Our ref: NO/2025/116529/01-L01
Your ref: 3/2024/0834
Date: 24 January 2025

**PROPOSED CONVERSION OF AN EXISTING RETAIL UNIT WITH ACCOMMODATION AT FIRST FLOOR OVER INTO A BOUTIQUE HOTEL WITH RESTAURANT INCLUDING THREE-STOREY EXTENSION TO SIDE, TWO AND THREE STOREY EXTENSIONS TO REAR, BUILDING UP AND EXTENSION OF EXISTING REAR OUTRIGGERS WITH ADDITION OF WINDOWS AND ROOFLIGHTS, ROOF TERRACES, NEW FLUE ABOVE RIDGE LEVEL, NEW BIN STORE TO SIDE, NEW BOUNDARY TREATMENT TO SIDE AND REAR AND USE OF LAND TO FRONT AND SIDE FOR OUTDOOR DINING.
69 KING STREET, WHALLEY, BB7 9SW**

Environment Agency position

Drawing title  
Proposed site plan

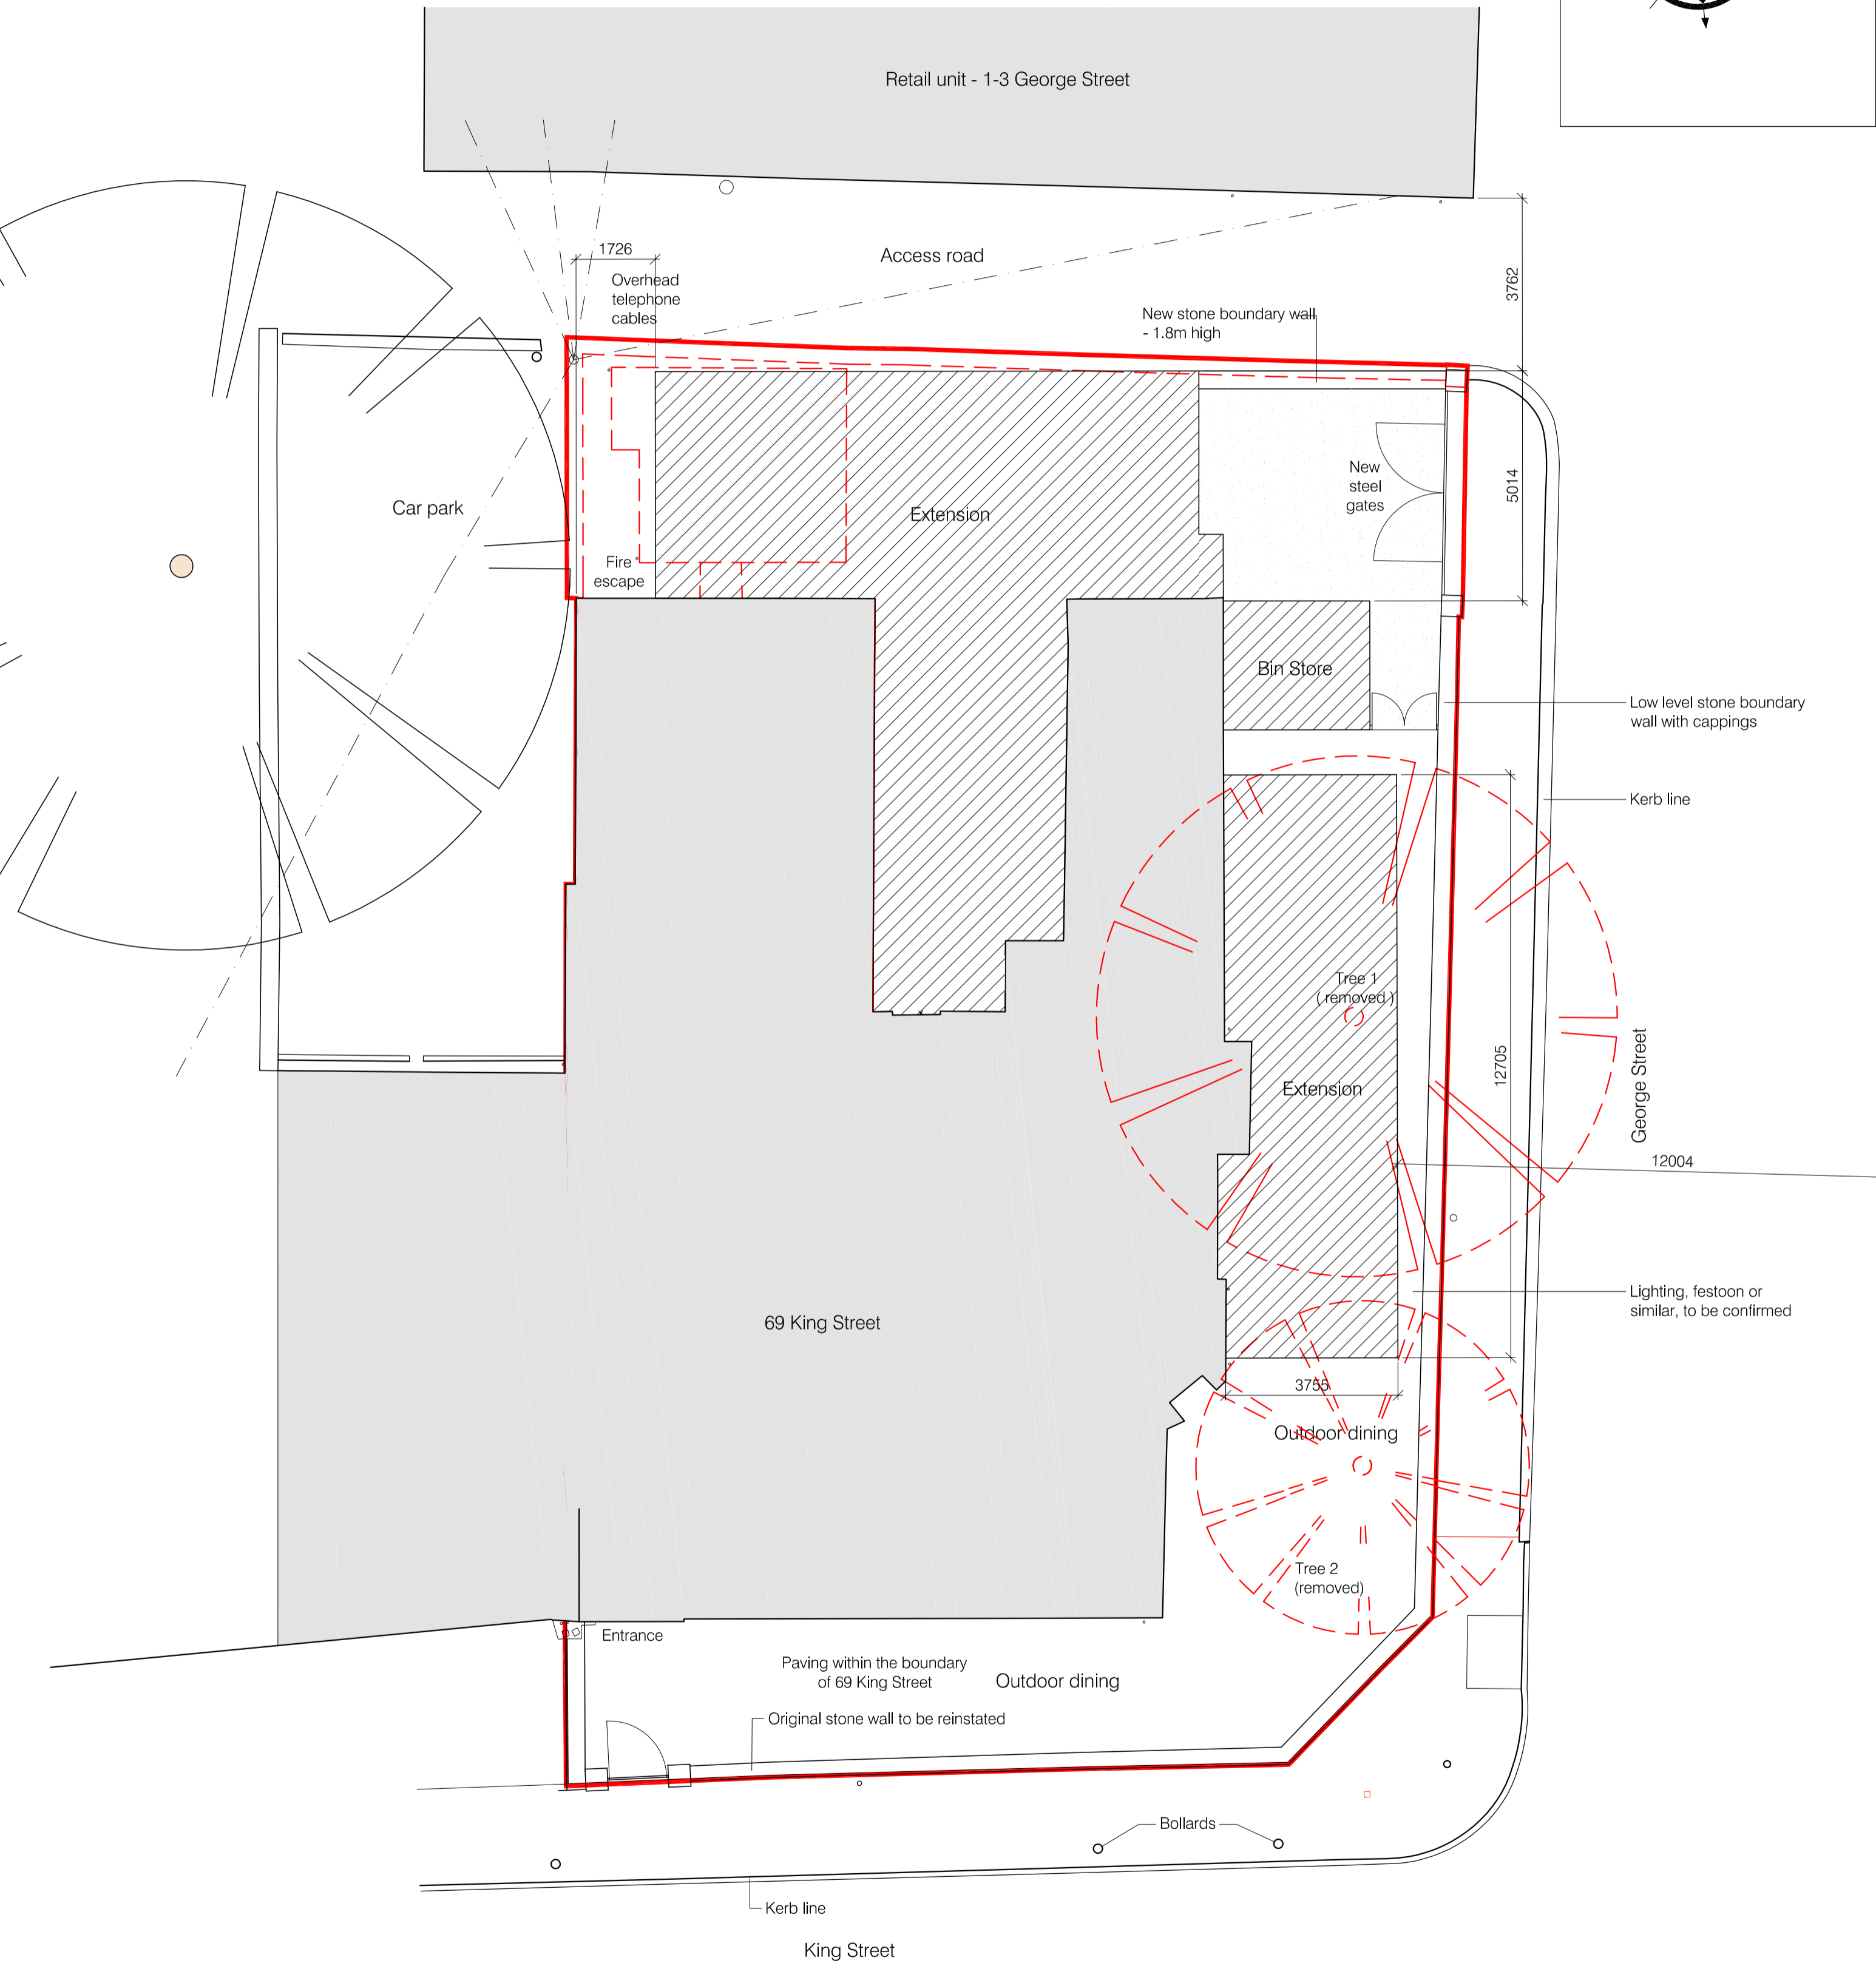
The proposal description includes the statement 'Reinstate the Existing Wall': as part of the redevelopment, it is proposed that the existing wall that surrounds the site adjacent to George Street, that has been previously removed from in front of the building on King Street, is reinstated.

The FRA goes on to state that 'Given that the EA flood maps indicate that the risk of flooding is from the road on King Street reinstating the wall here will provide additional protection from flooding. This wall should be at a minimum height of 48.17m AOD to protect the building from the 0.1% level plus 0.6m freeboard for climate change allowance. The gate access in the wall should be fitted with a flood barrier to the same height as the wall.'

The proposed wall inclusive of the flood gate would extend into areas indicated on the Environment Agency's Flood Map for Planning (FMfP) as being in Flood Zones 2 and 3. The FRA includes no assessment of the potential to displace or direct flood risk elsewhere. The FRA should be amended to include consideration of what is effectively a flood wall proposal.

To overcome our objection, the applicant should submit a revised FRA which addresses the points highlighted above. If this cannot be achieved, we are likely to maintain our objection. Please consult us on any revised FRA submitted and we will respond within 21 days of receiving it.
